**PROPOSED ROAD UPGRADE WORKS
AT BELVIEW, CO. KILKENNY**

Road Safety Audit Stage 1

Project Title	Proposed Road Upgrade Works at Belview, Co. Kilkenny
Project No.	25045-02
Document Title	Road Safety Audit Stage 1
Document No.	25045-02-001

Drawing No.: **12001-2002** Revision: **D6**

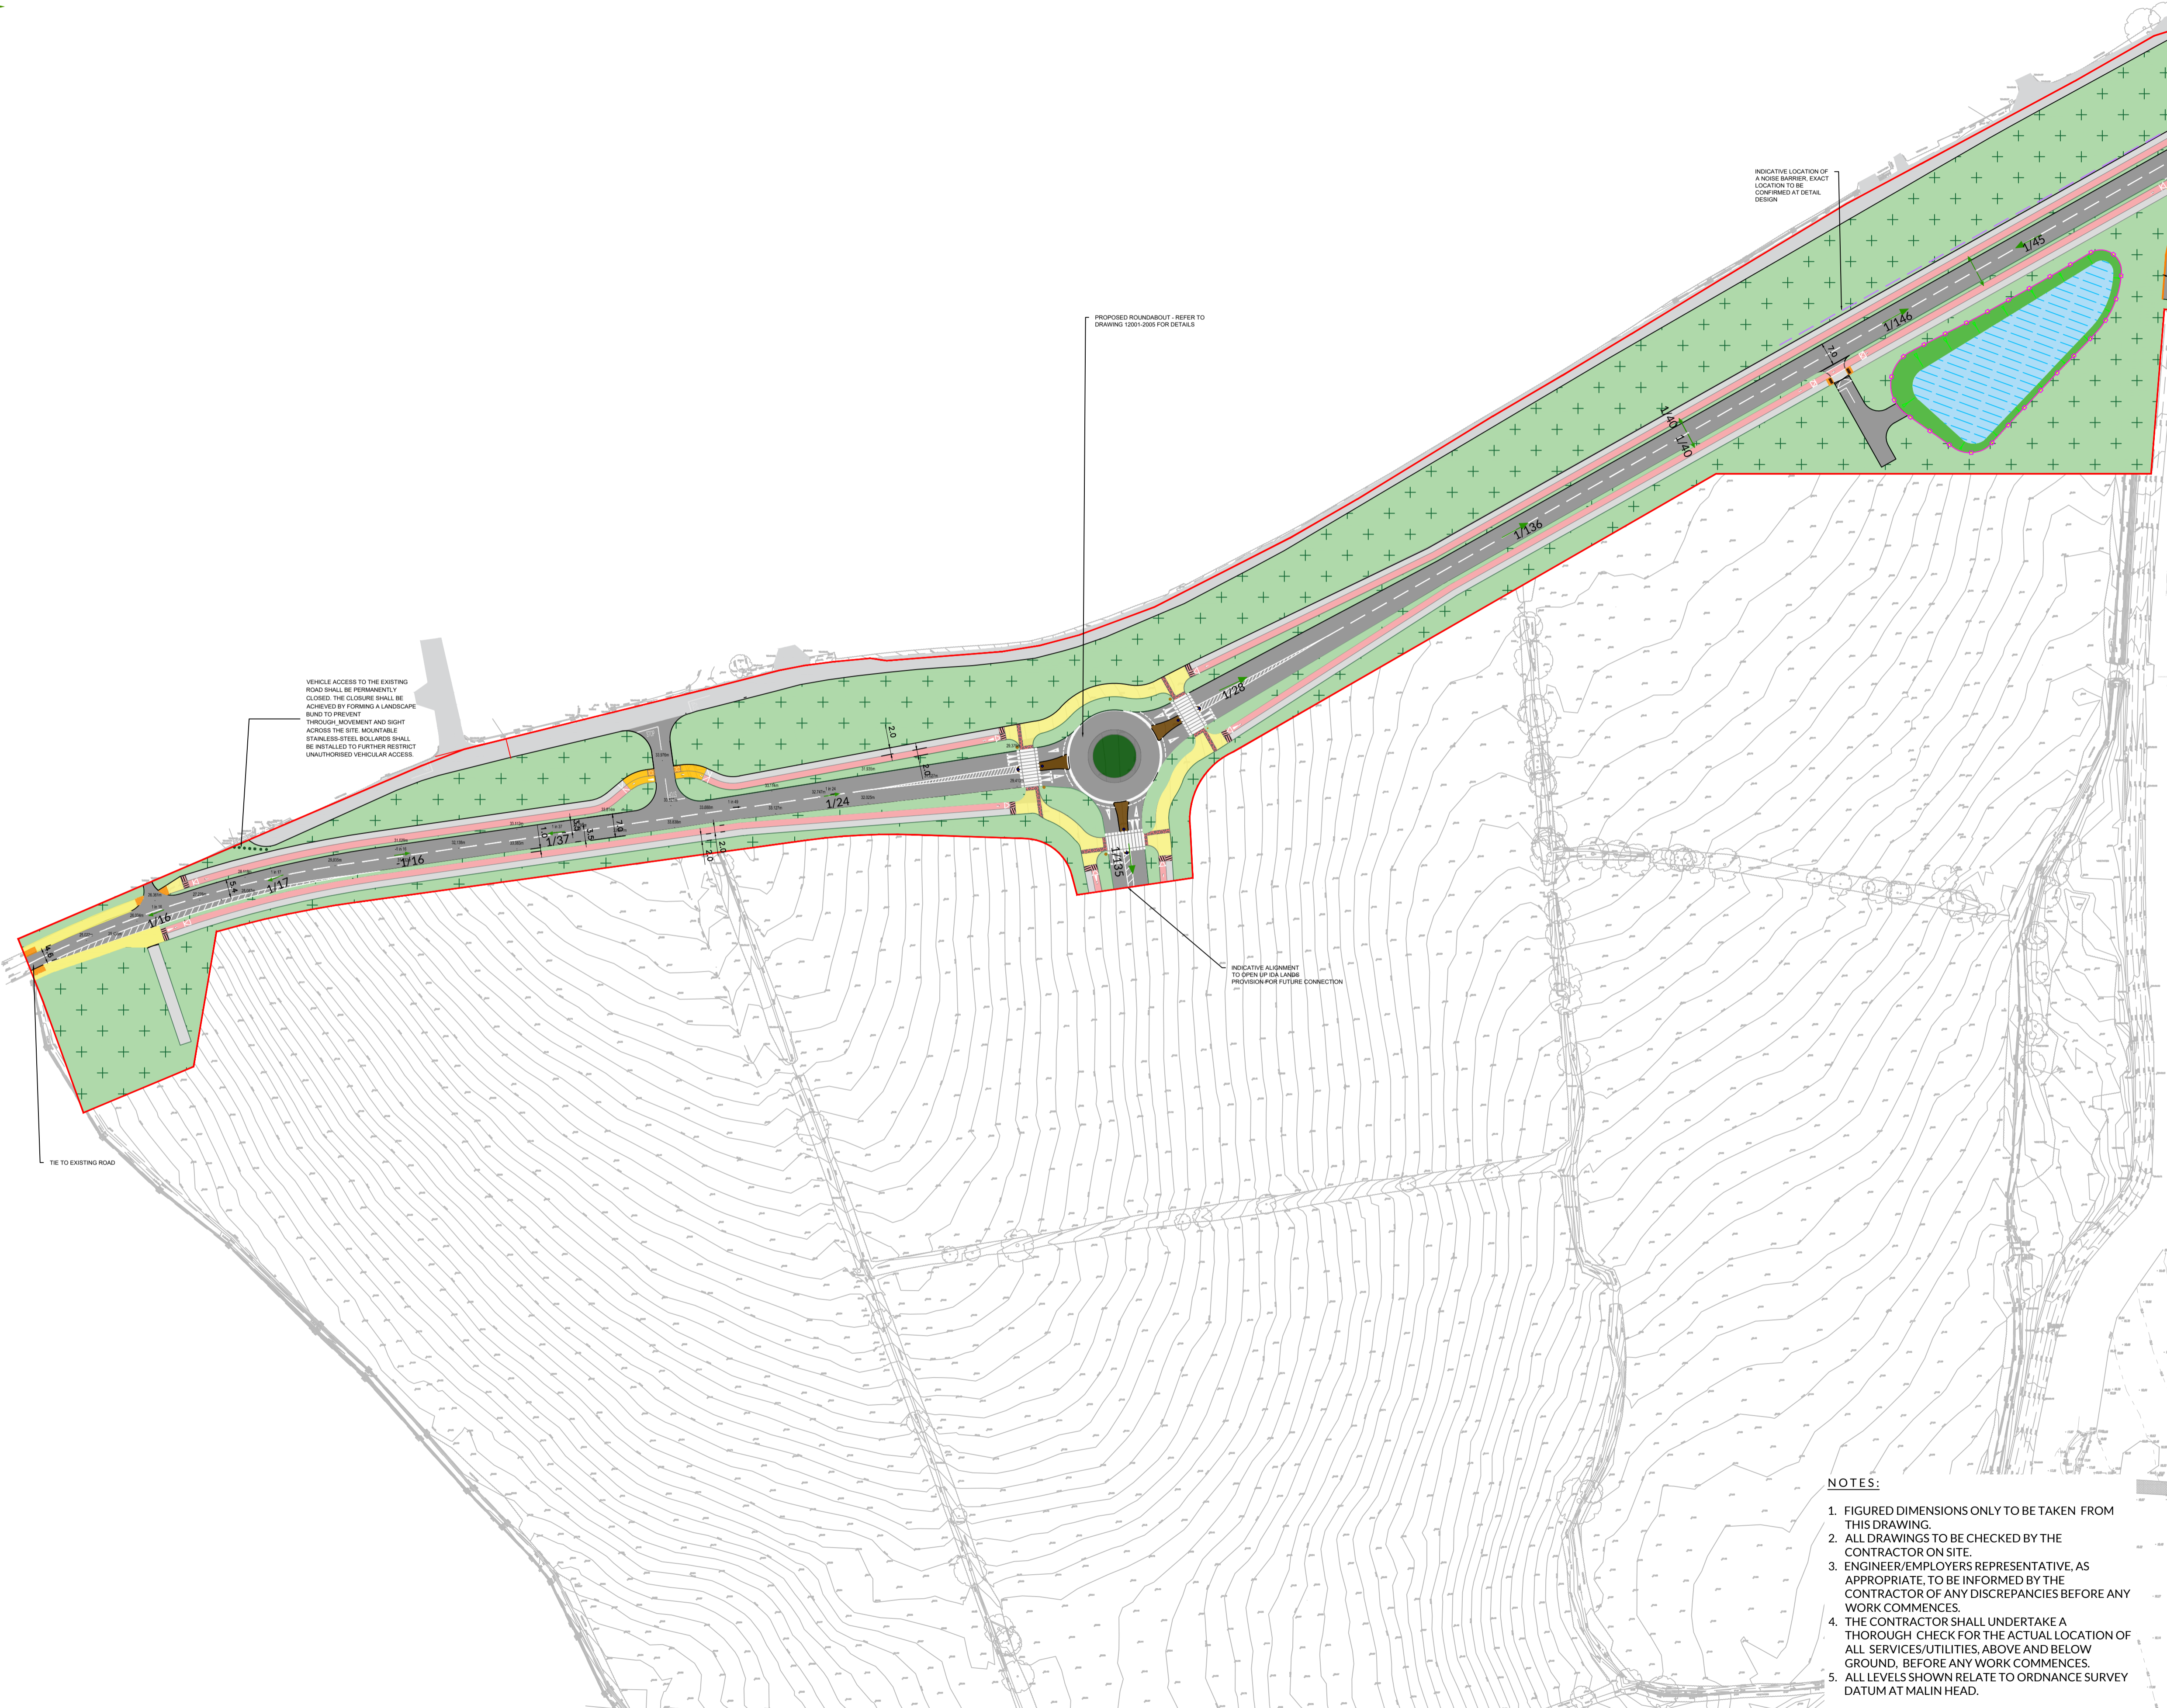
2.8 **Problem:** Inadequate Lane Width

Location: Near Western tie in

The lane width of the westbound lane appears to be narrow compared with the eastbound lane. This reduced width may not provide sufficient clearance for vehicles when encountering heavy vehicles in the opposing lane. As a result, there is an increased risk of side-swipe collisions.

Recommendation: The layout should be amended so that the width and curvature of each lane is adequate for vehicles to pass safely.

Drawing No.: **12001-2008**      Revision: **D2**

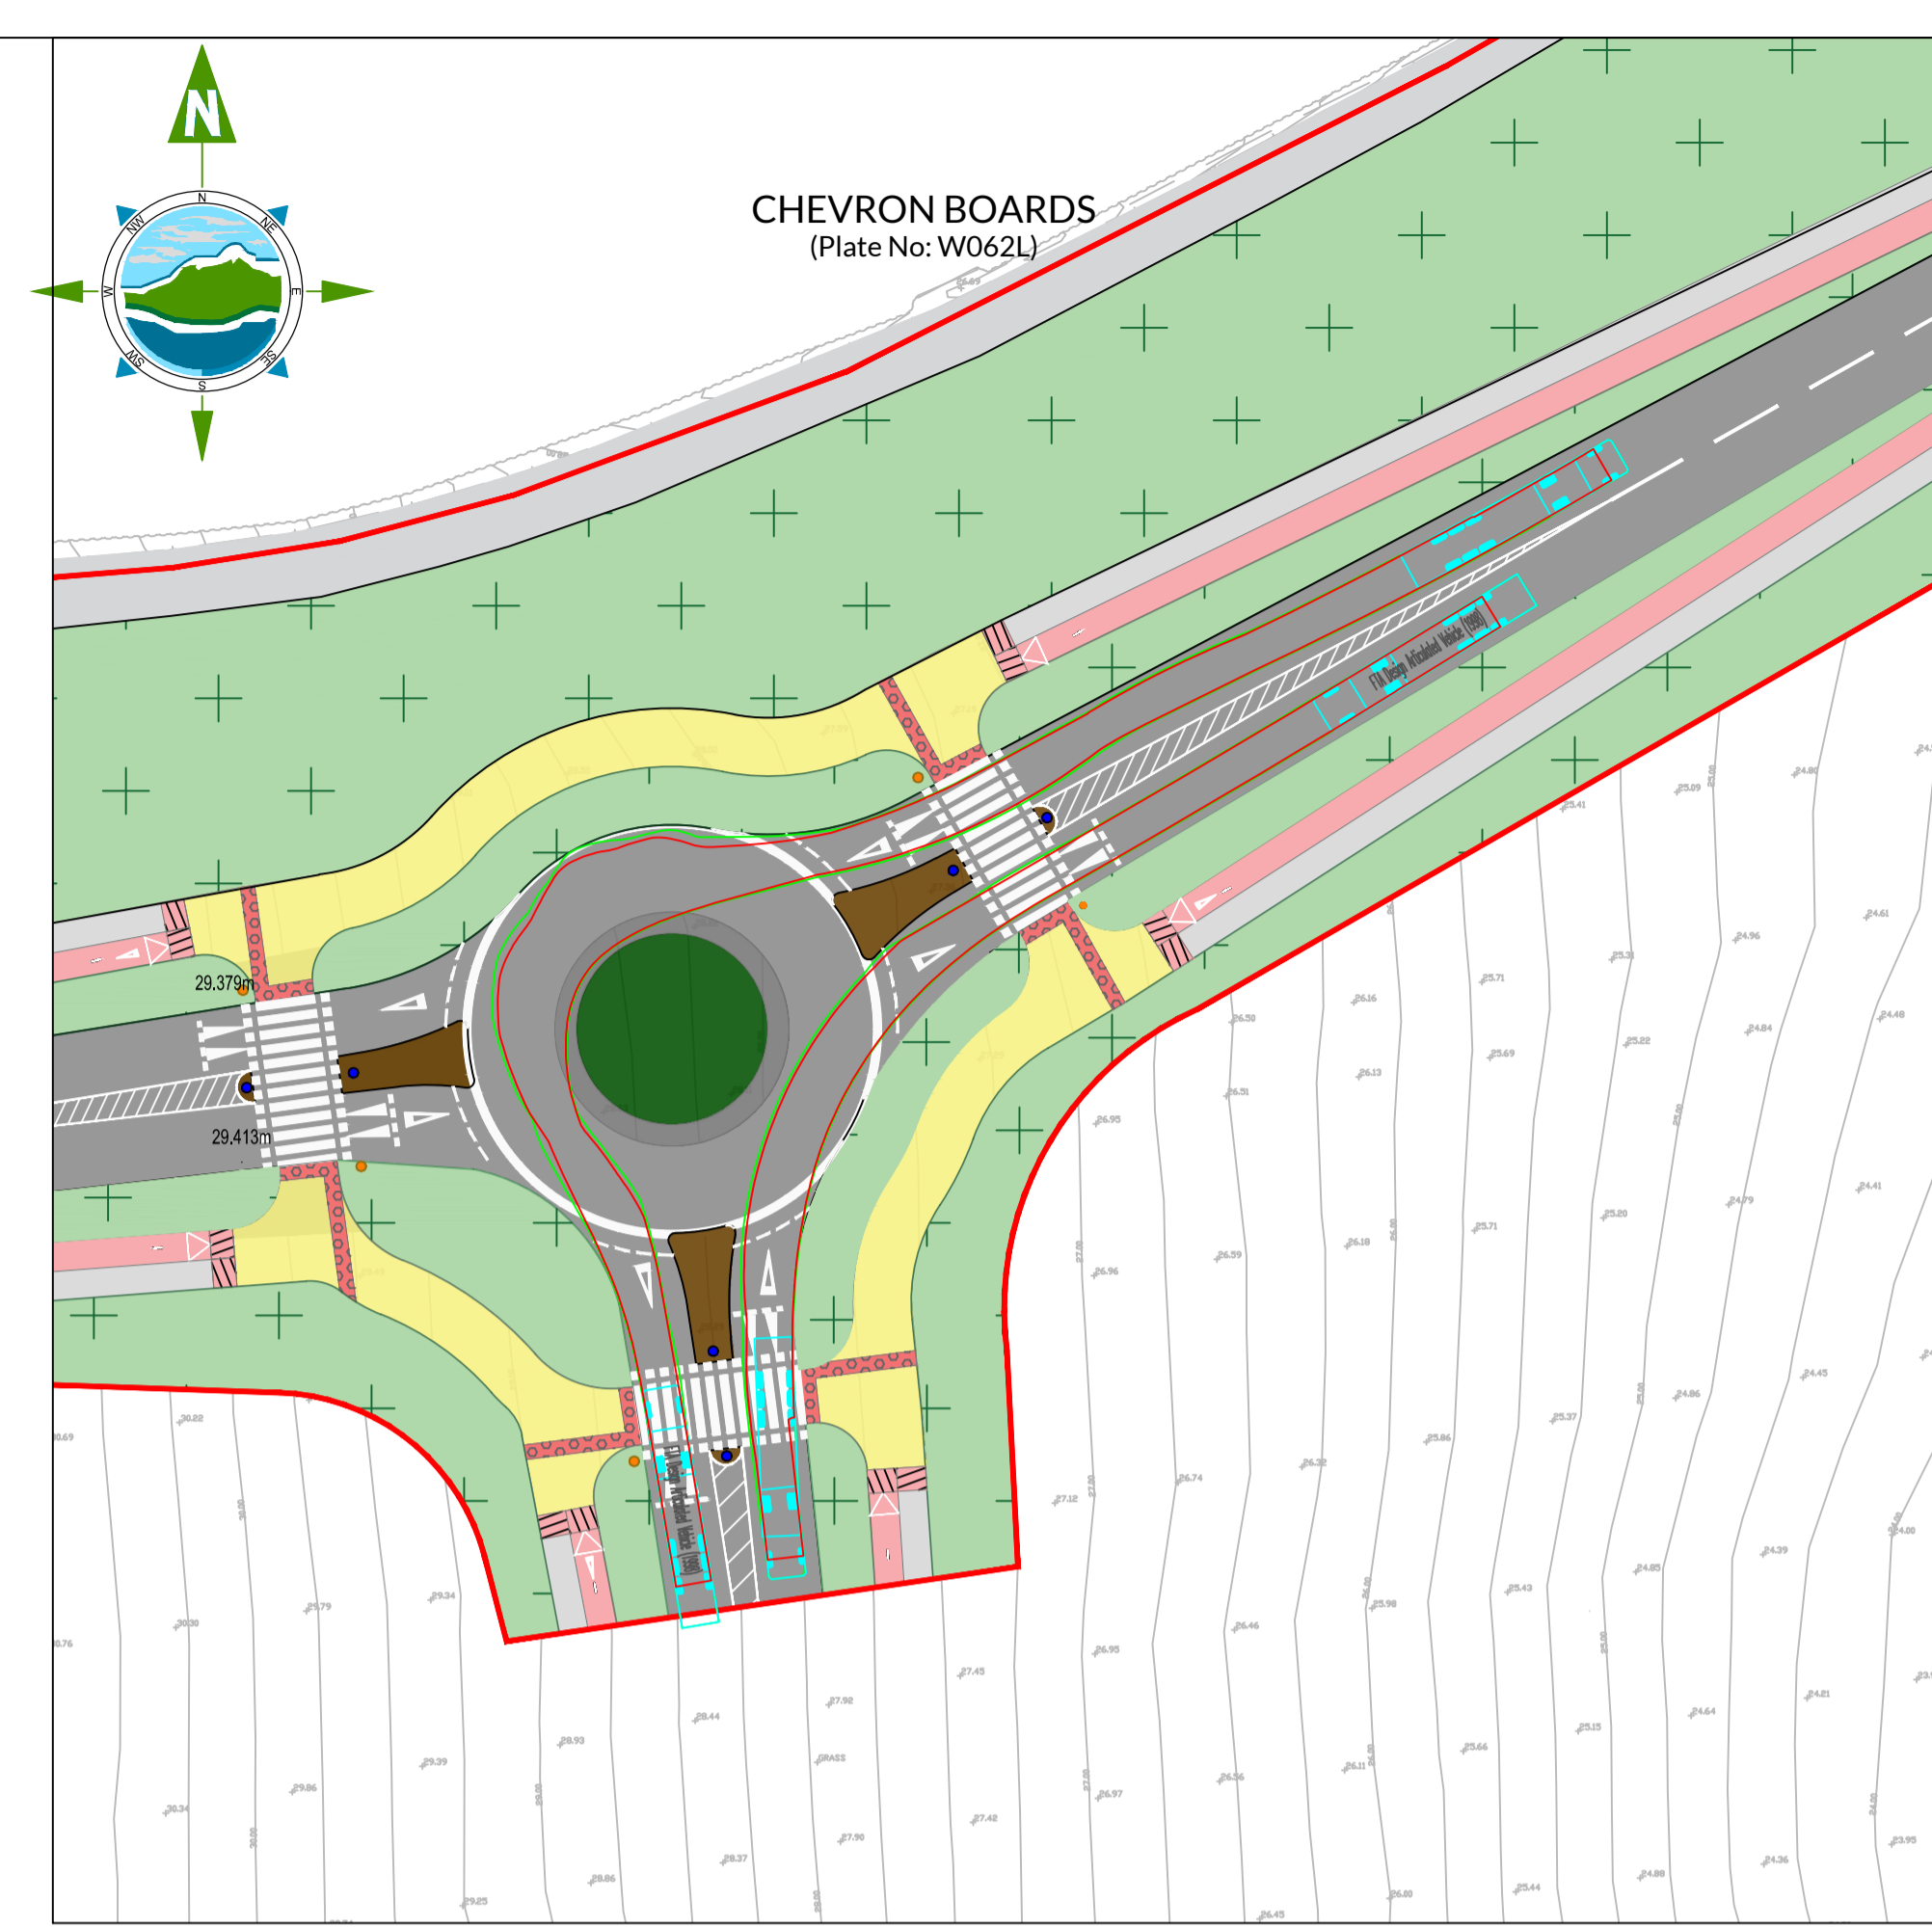
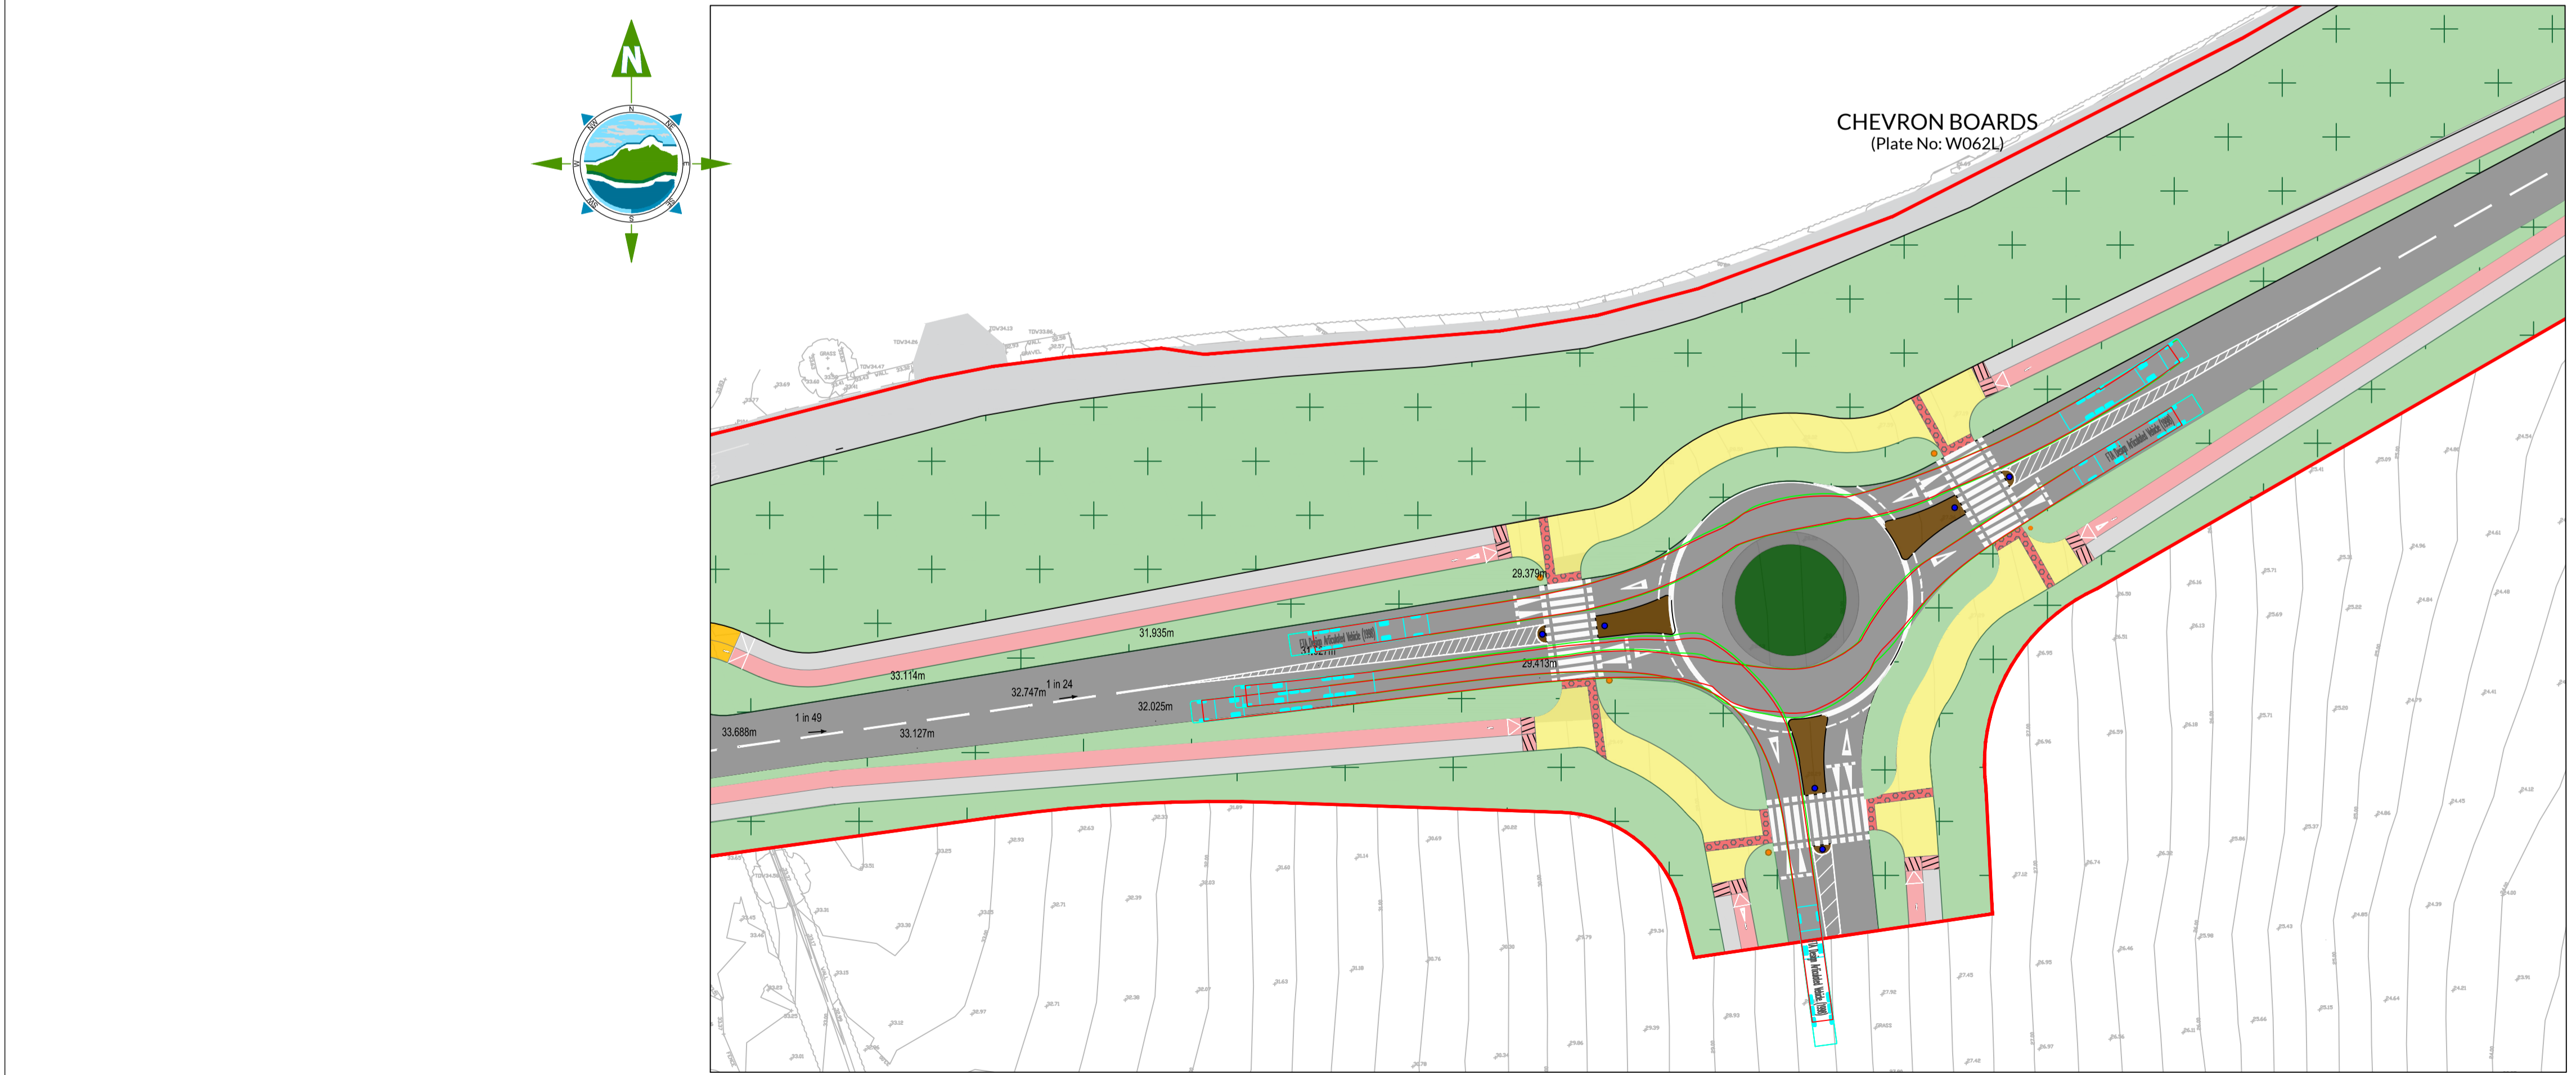
2.11 Problem: Insufficient turning width

Location: Western arm of western roundabout

The swept path analysis indicates that there is insufficient space to accommodate turning within the road surface by the design vehicle. This may lead to unanticipated movements and associated collisions.

Recommendation: Adequate space should be provided to accommodate anticipated vehicles.
